BE/30/20/HH

1 Homing Gardens Bersted West Sussex PO22 9AJ

First floor extension & re-positioning of boundary wall (Re-submission of BE/113/19/HH).

sheet 5 of 5

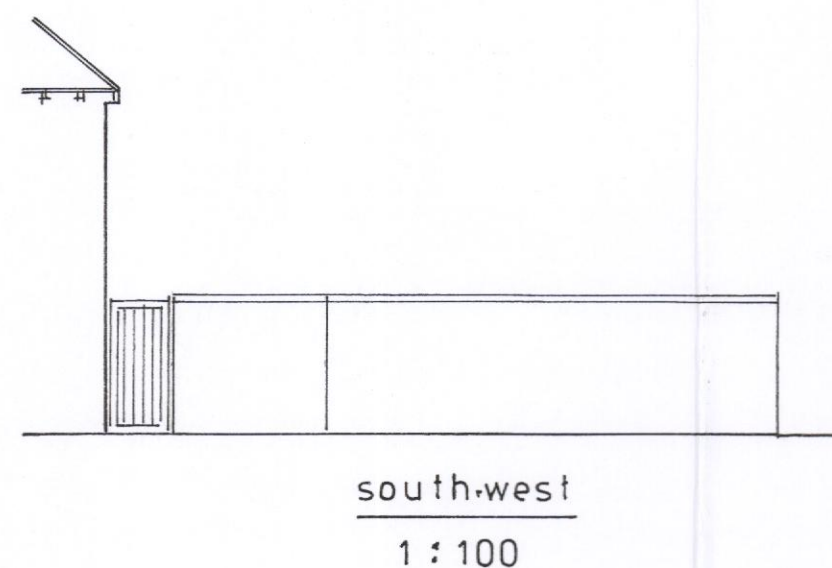
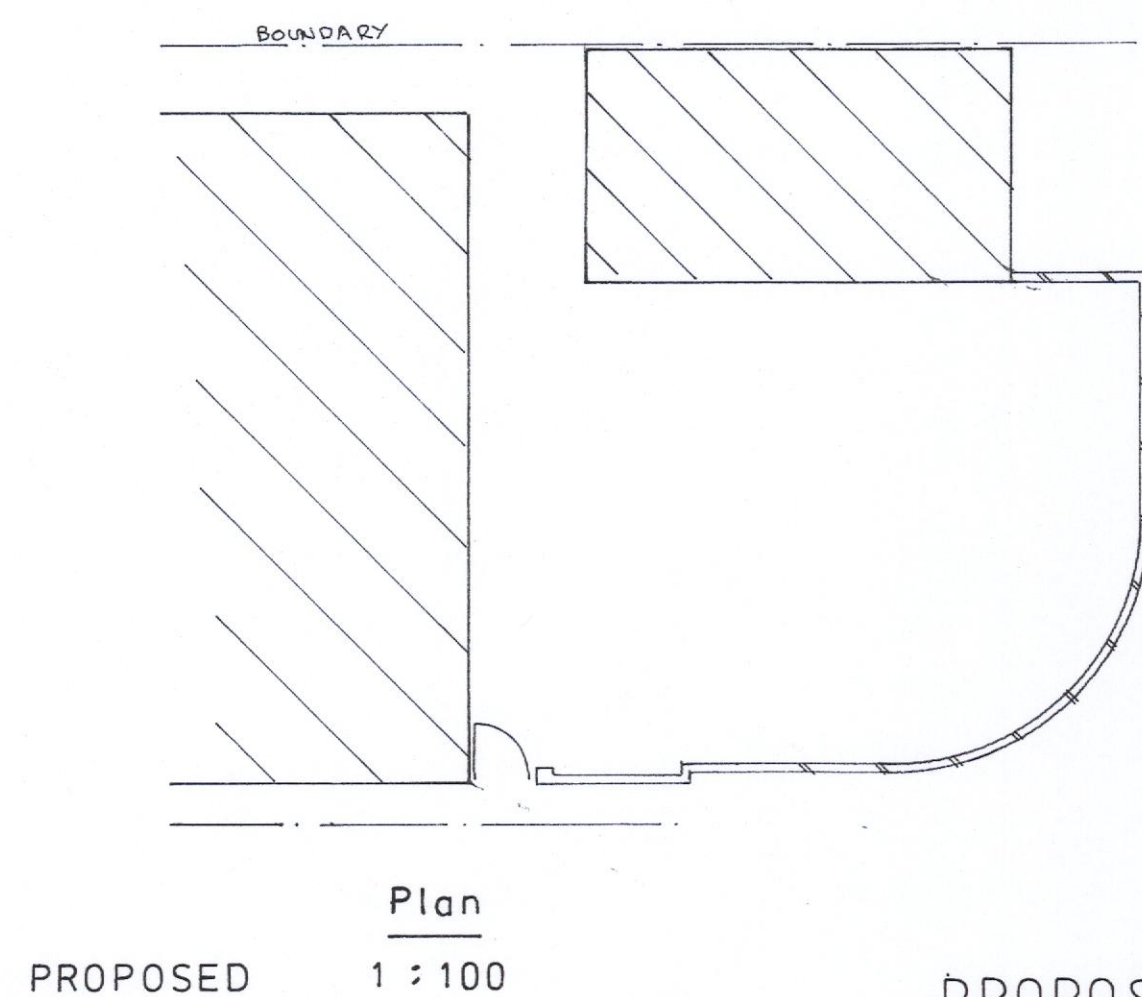
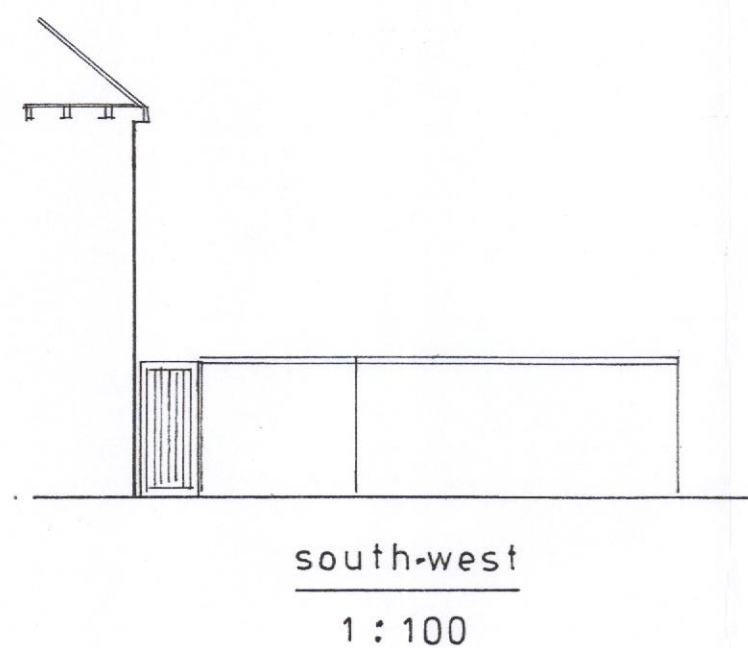
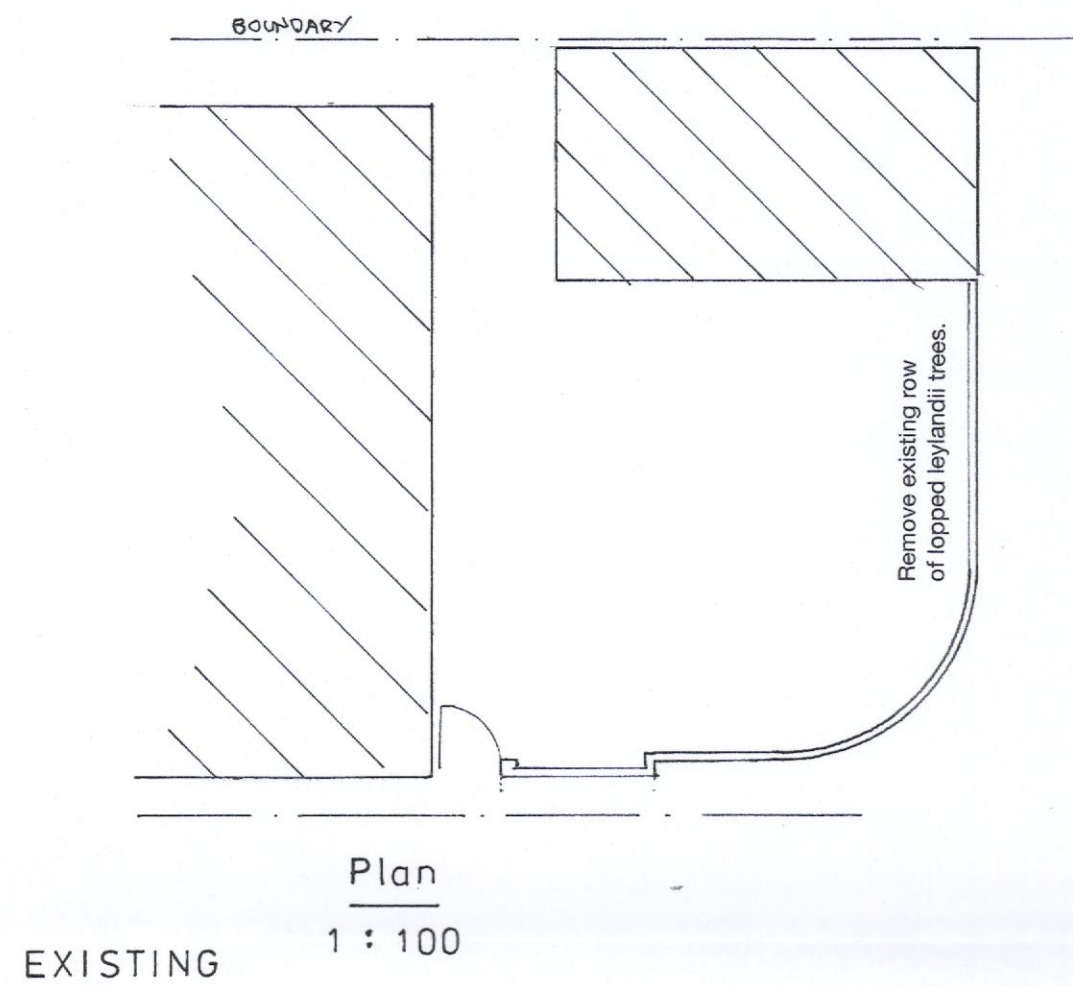
It would appear that the proposed alterations to the boundary walling would result in the loss of a leylandii hedge. Whilst it is unfortunate that there would be a loss of some greenery in this location, it will not unduly harm the character of the small road it is facing, or the local area.

sheet 2 a of 5

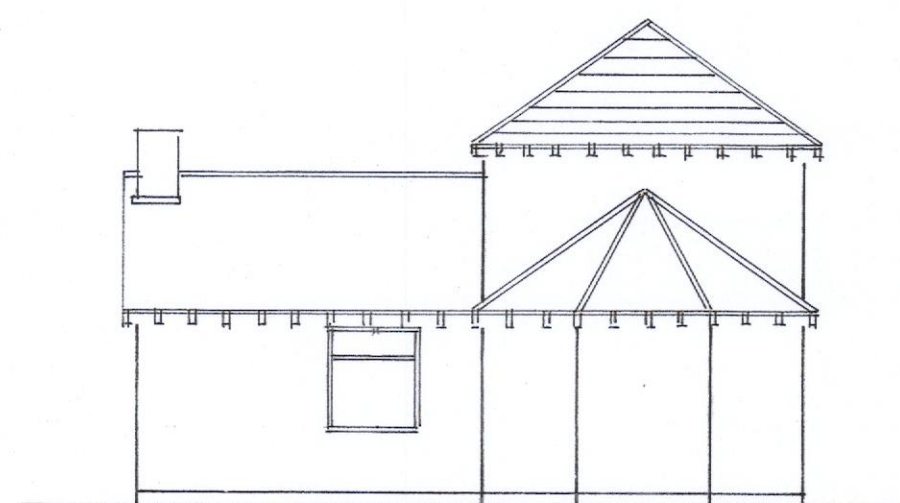
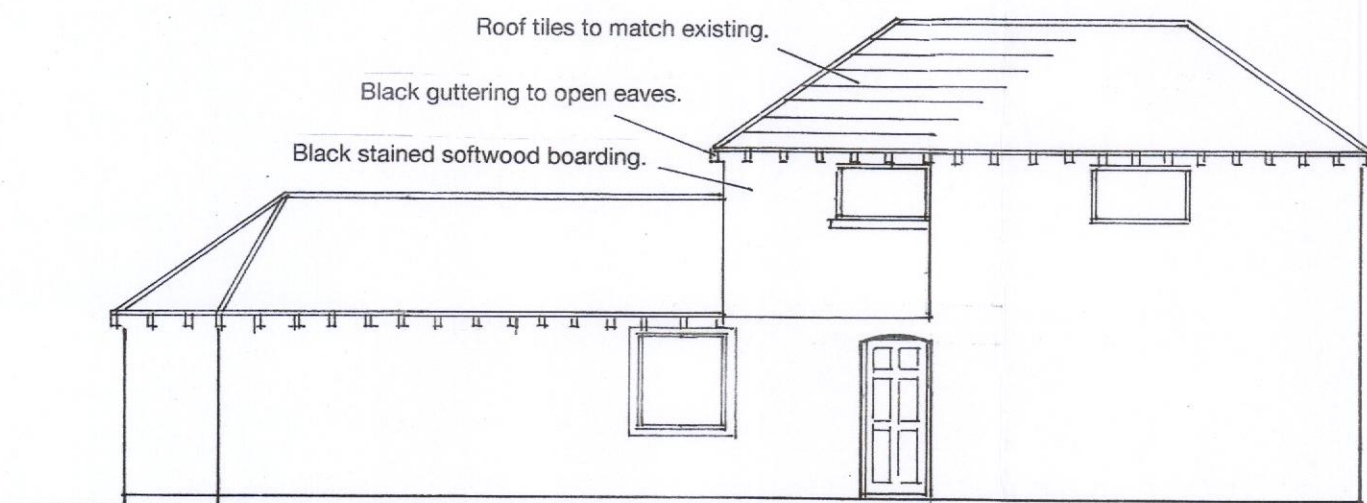
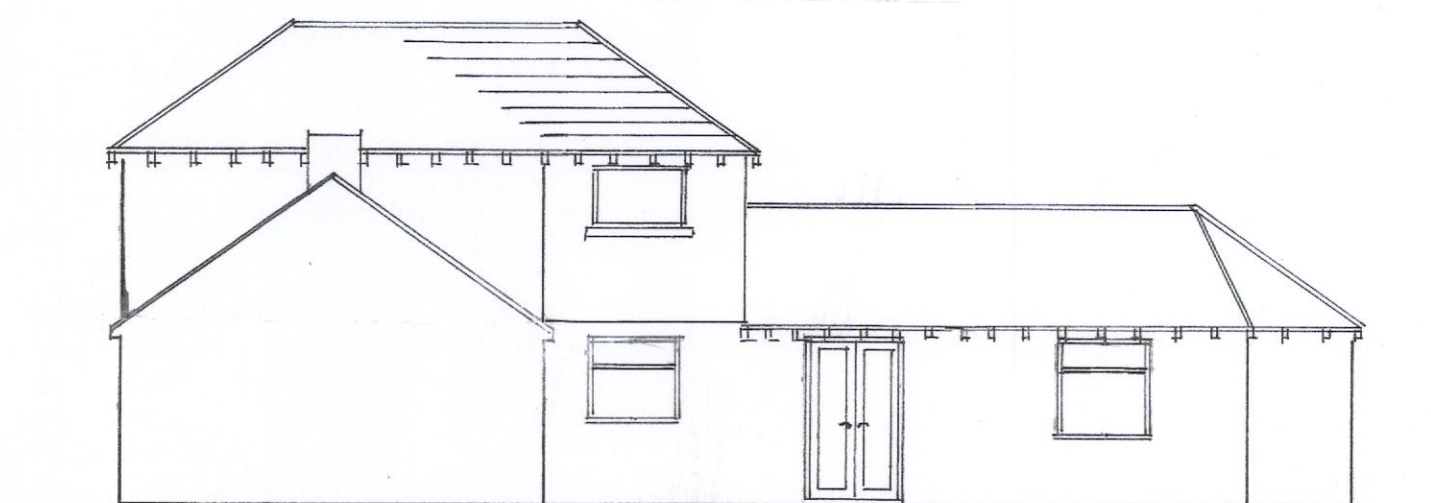
I note that the plans indicate that stained softwood boarding is to be used, whilst the Design and Access Statement refers to Marley Cedar Boarding. Please can the correct material be confirmed? I would request that wood is used as this is a traditional material and would enhance the appearance of the building. A dark paint/stain is acceptable. Further, would the cladding cover the entire of the first floor?

It is also noted that there are changes proposed to a window and a door. Such alterations are considered acceptable and will not cause harm. It is suggested that traditional window and door design would improve the appearance of the building.
